STATE OF NORTH CAROLINA
DEPARTMENT OF TRANSPORTATION

Addendum No. 1

RE: Contract # C204543

I-95 FROM SR-1002 (EXIT 71) TO I-40 (EXIT 81)

PROJECT REFERENCE NO. <b>W-5600</b>	SHEET NO. <b>UC-27</b>
DESIGNED BY: <b>SS</b>	DATE: <b>11/25/2019</b>
DRAWN BY: <b>SS</b>	
CHECKED BY: <b>MVZ</b>	
APPROVED BY: <b>MVZ</b>	
REVISED:	
NORTH CAROLINA DEPARTMENT OF TRANSPORTATION	
UTILITIES ENGINEERING SEC. PHONE: (919) 707-6690 FAX: (919) 250-4151

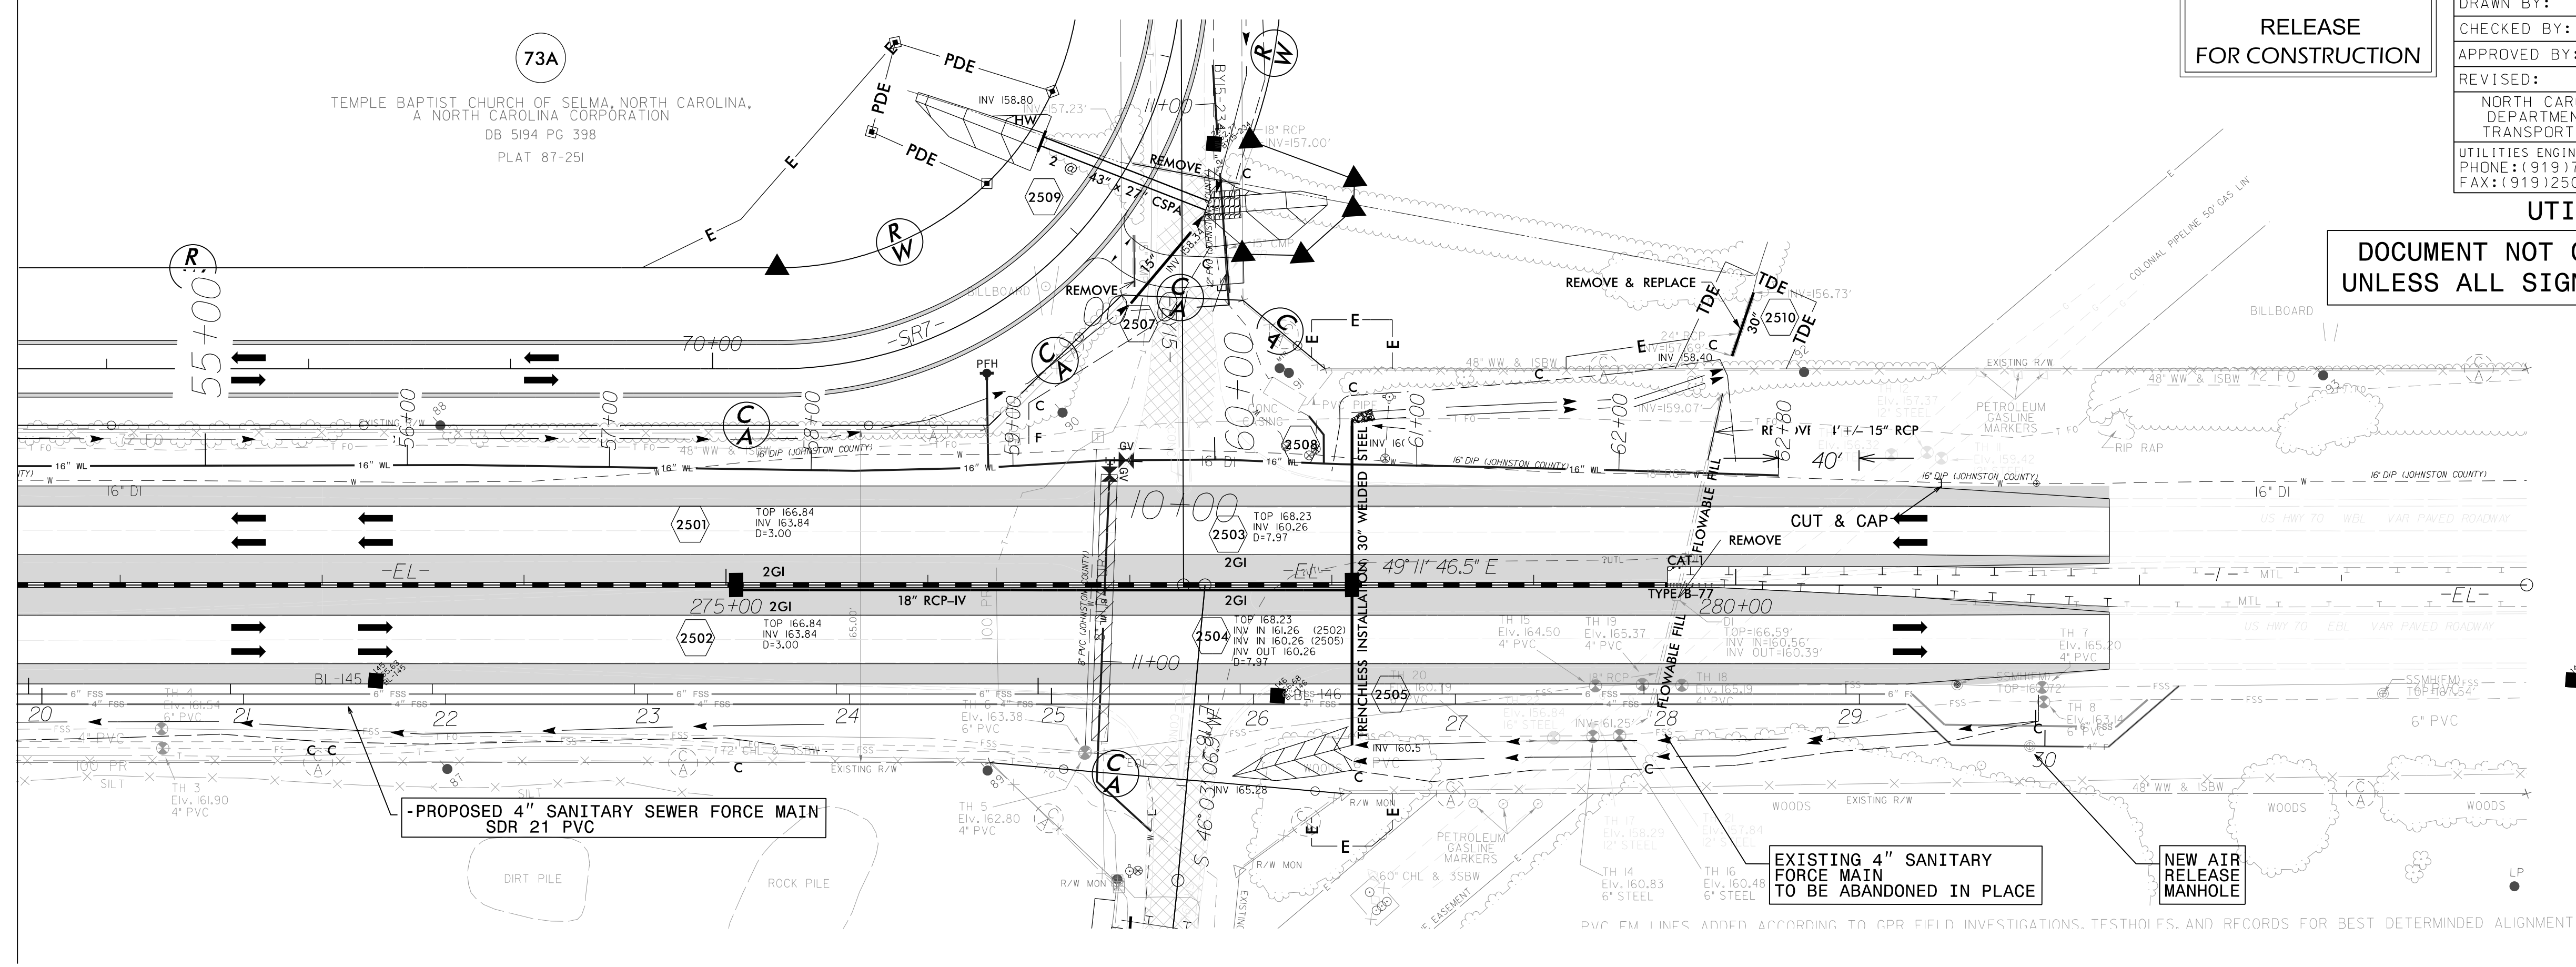
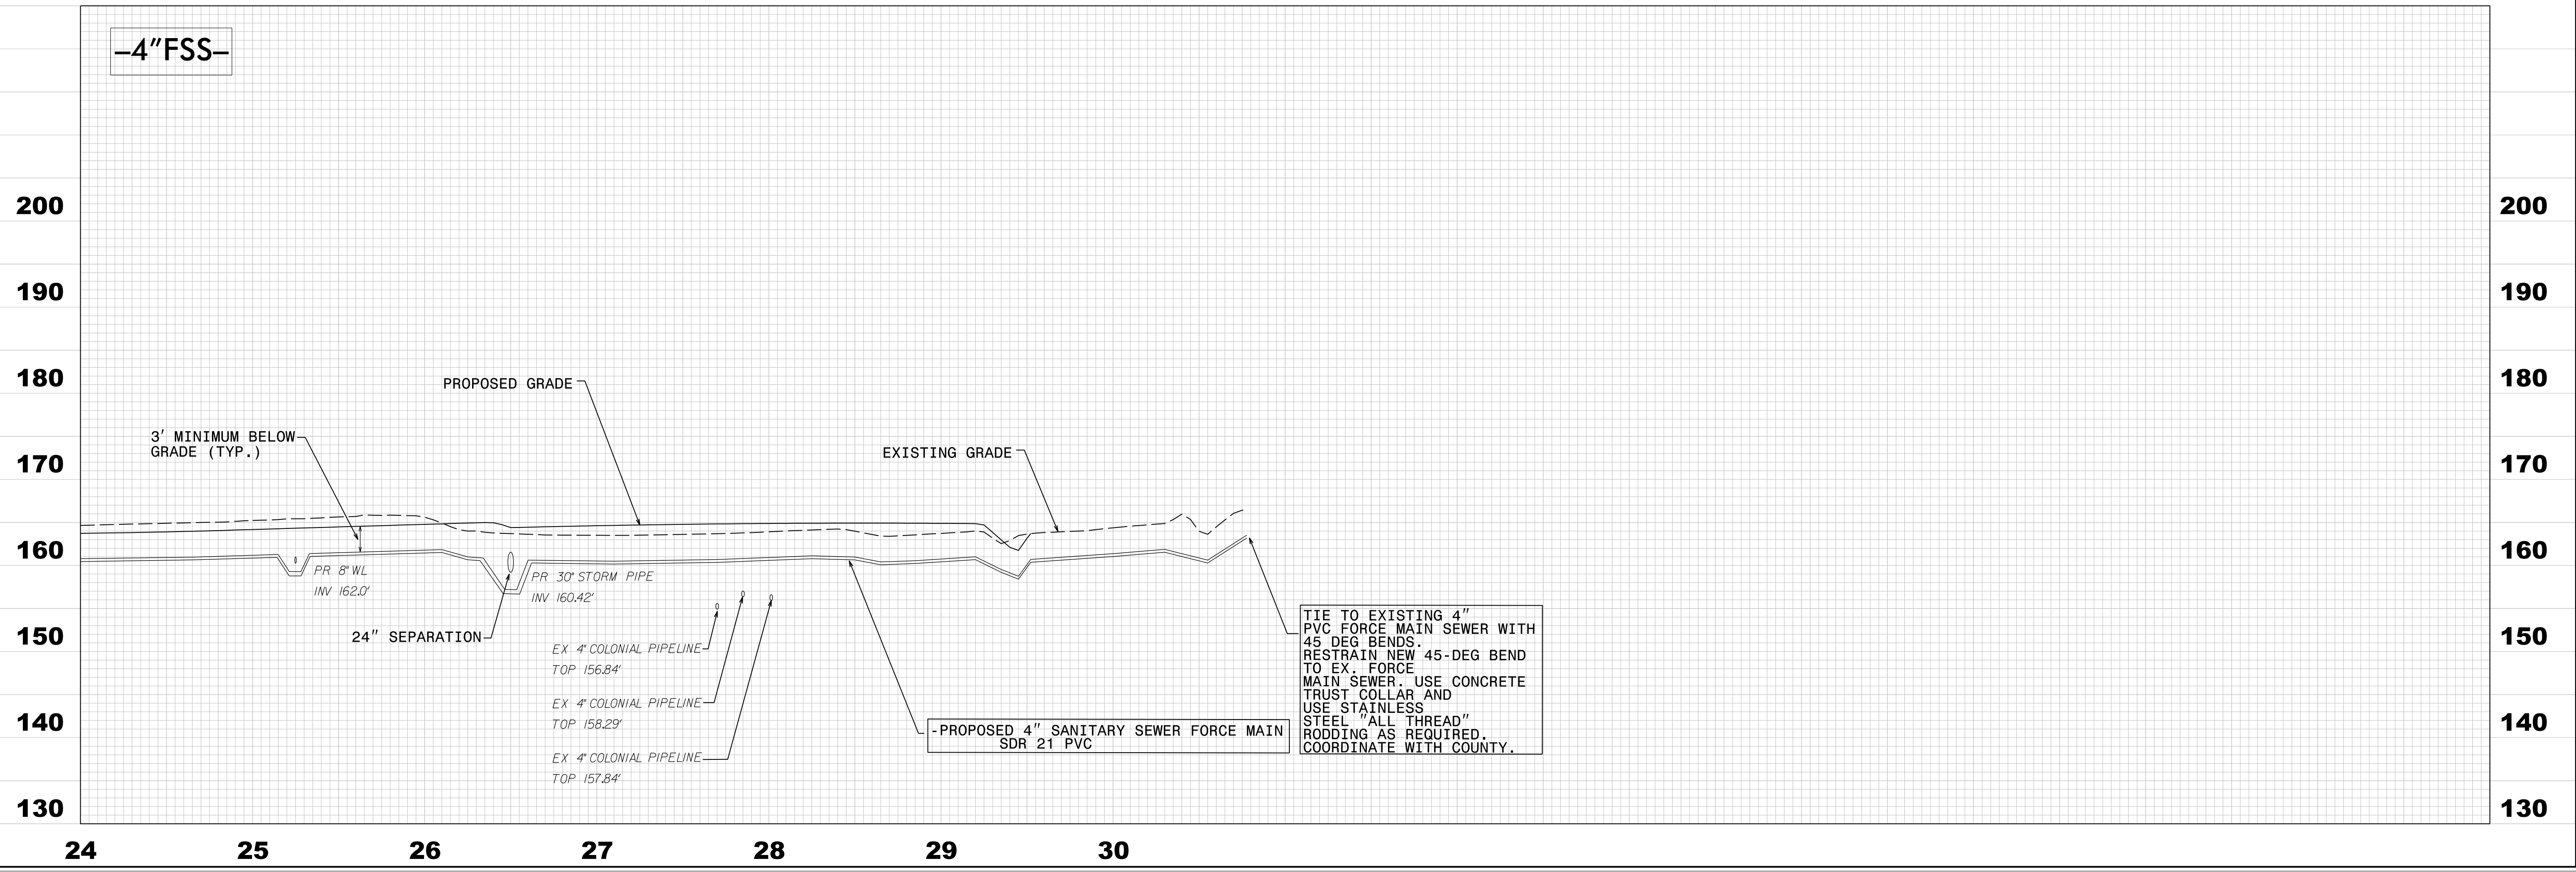
(I-5878) TMP-18A	Cross section revised due to SR13 profile change.
(I-5878) UC-7C, UC-14, UC-27	Added fluoroelastomer gaskets along water line PW700 through and past contaminated soils. No quantity changes.
(I-5878) UC-16, UC-30	Revised water line to avoid signs on Parcels 302 & 303.
(I-5878) UO-4 thru UO-5	Updated due to revised drainage for drives added to Parcels 45, 46, & 47.
(I-5878) UO-14	Updated to show additional TCE.
(I-5878) X-1A, X-1F thru X-1G	Cross section summary sheets updated to reflect earthwork quantity changes shown below.
